From: pamcolbourne [REDACTED]
Sent: 03 December 2017 17:24
To: Planning.Responses
Subject: BR/208/17/PL

We are owner residents of 5, Mead Court. These are our comments on the proposed development.
(BR/208/17/PL)

Front Elevation

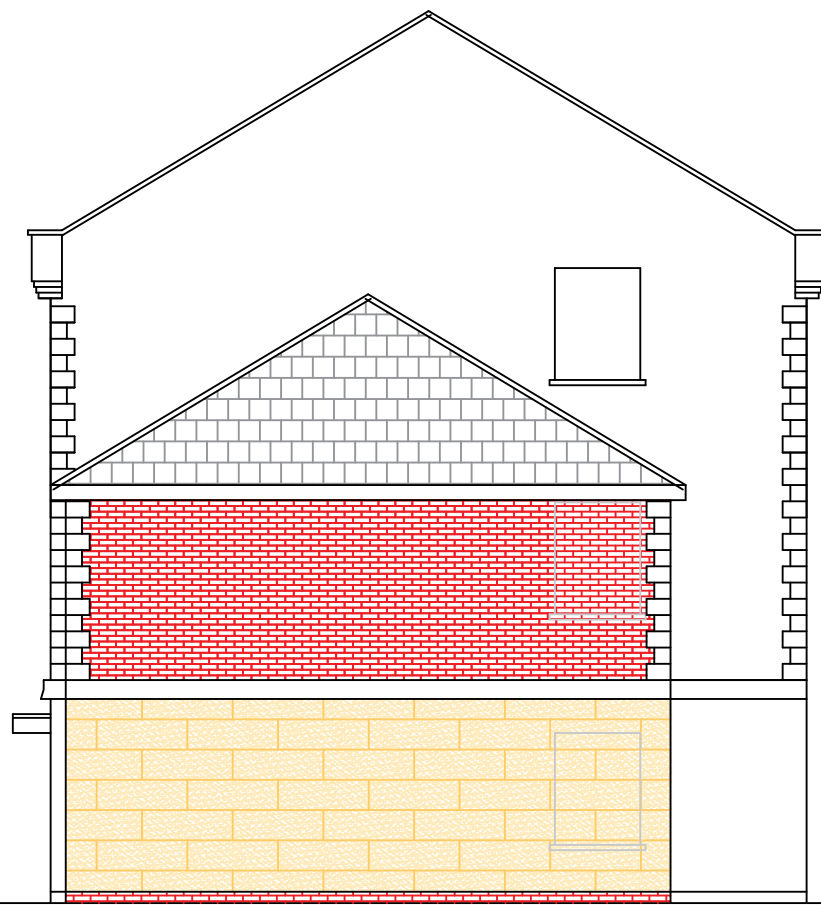
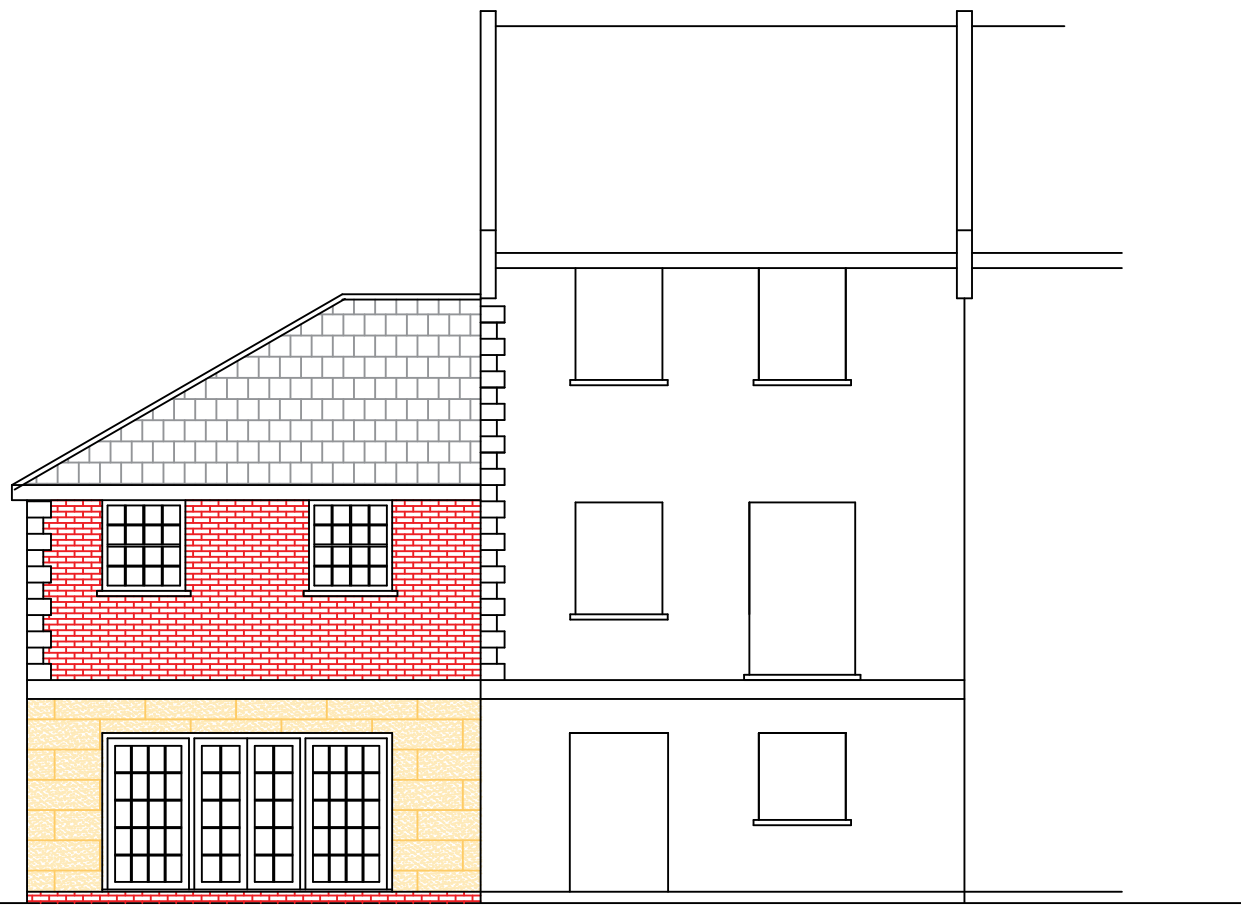
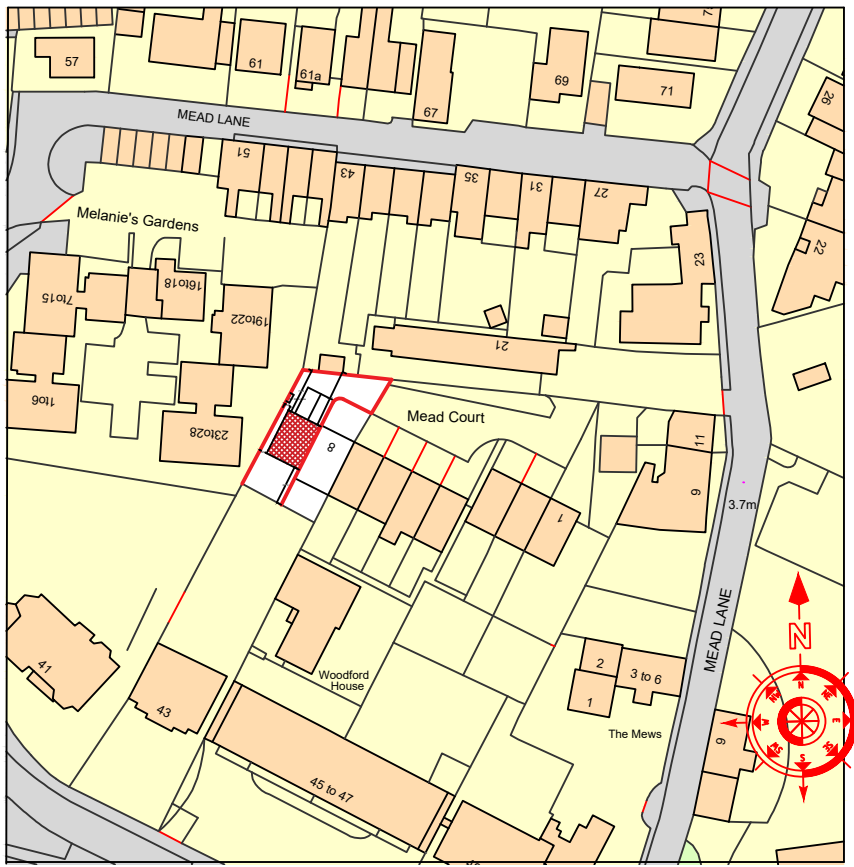
The proposed materials would not be in keeping with existing properties which are restricted by the Planning Department to timber doors and window frames. Having no garage, an odd shaped roof and two storeys wouldn't match either.

Block plan 1 : 500

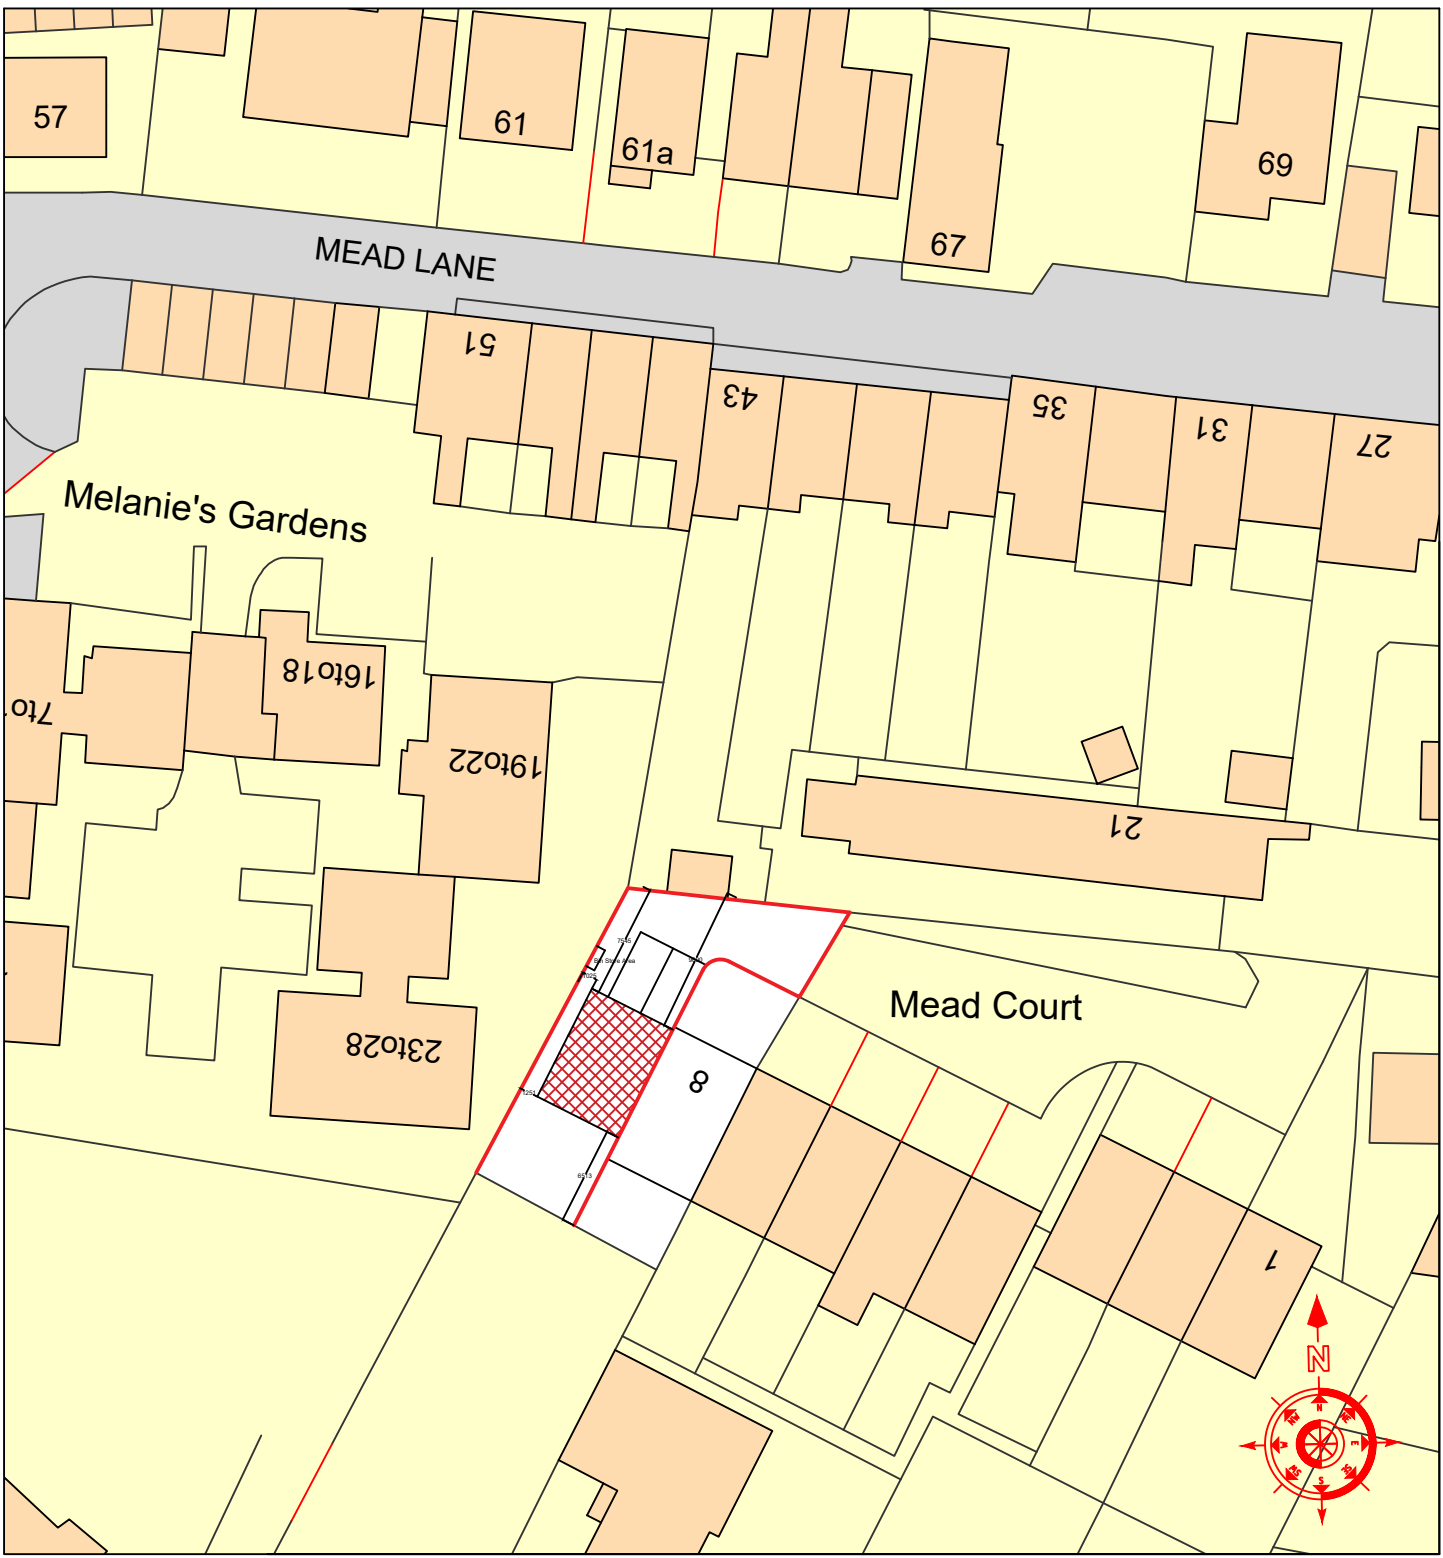
We have had problems with parking in the past and ask, that if development went ahead, provision would be made to keep vehicles inside the gate. The applicant states that the new house will have four spaces but given the lack of space, he must mean there will be two for the new house and two for No.8. A student HMO, potentially, would create more cars and the need for more parking - as we know from the roads around here.

The building would come very close to Melanie Gardens and have very little outside space.
